OUT19/16751

**West Nowra Landfill Expansion (SSD 7187) -
Response to Submissions**

Pre-approval Recommendation

Figure 5 Hydraulic Head Surfaces

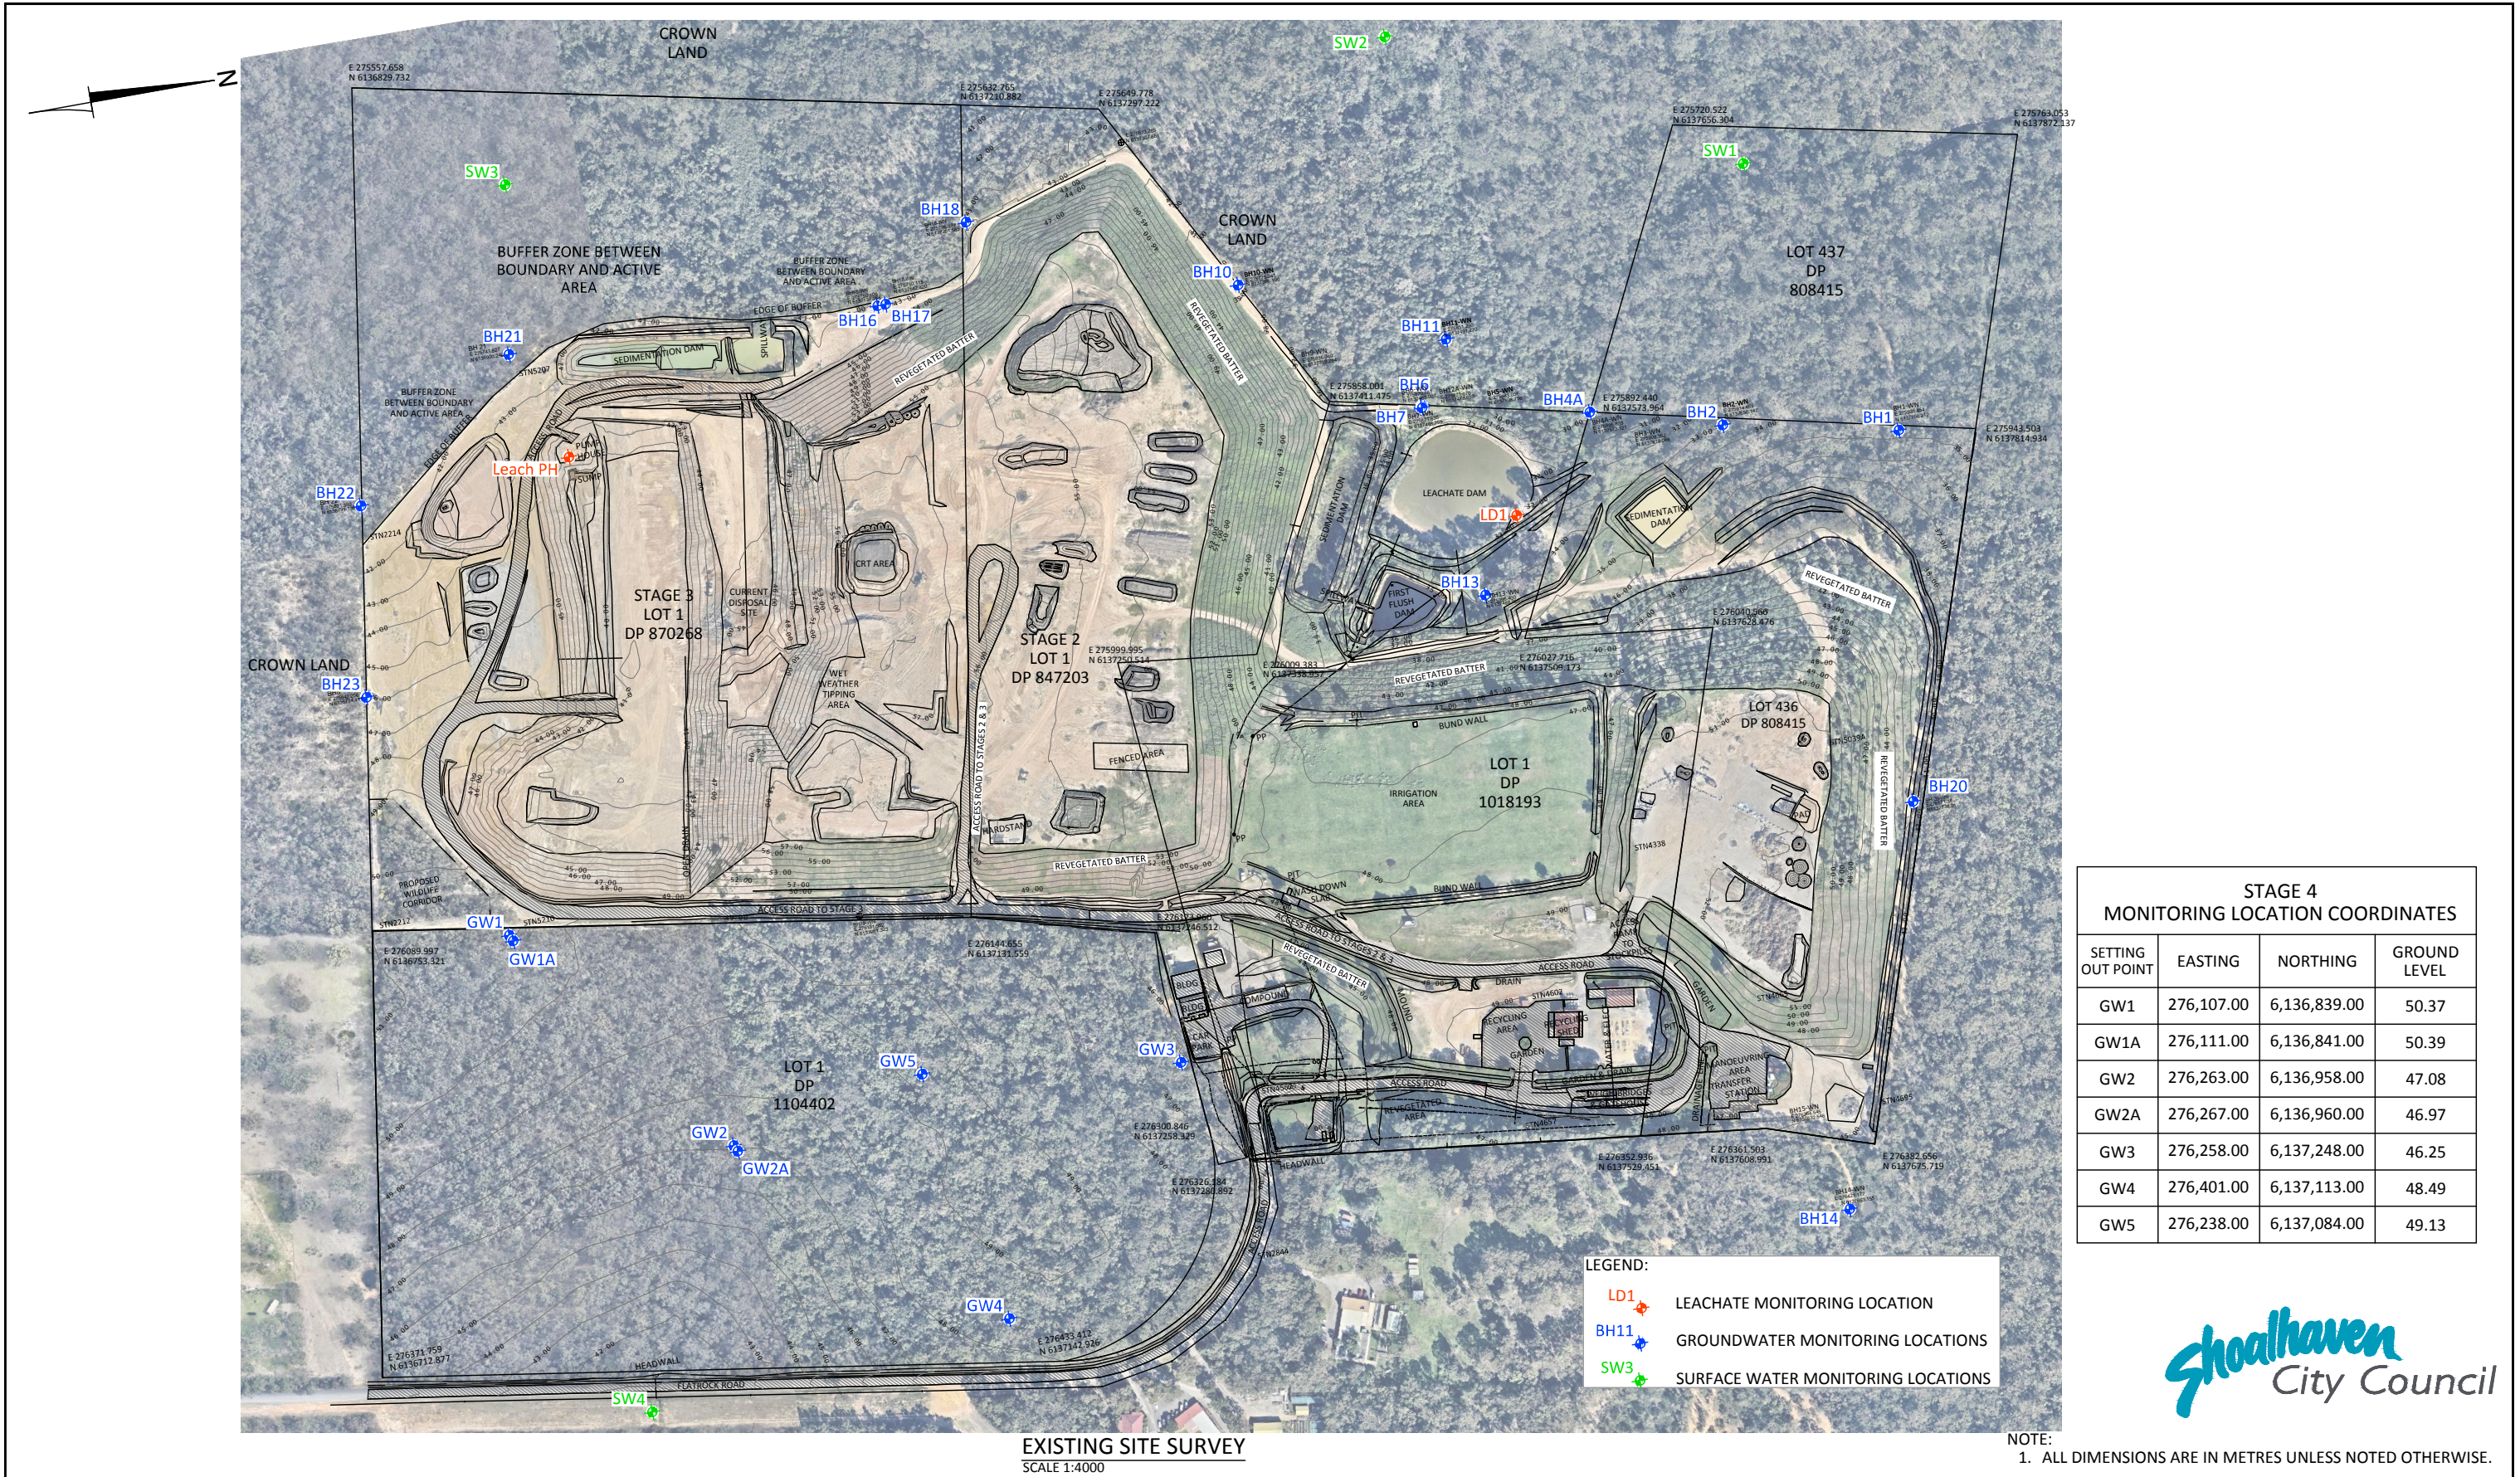
- It is recommended that the analysis section Appendix G of the submission be reviewed and modified with an extended level of analysis of water levels across the site and matters related to rainfall. This is to ensure proper analyses and consideration of maximum average groundwater levels with respect to cell invert depths.
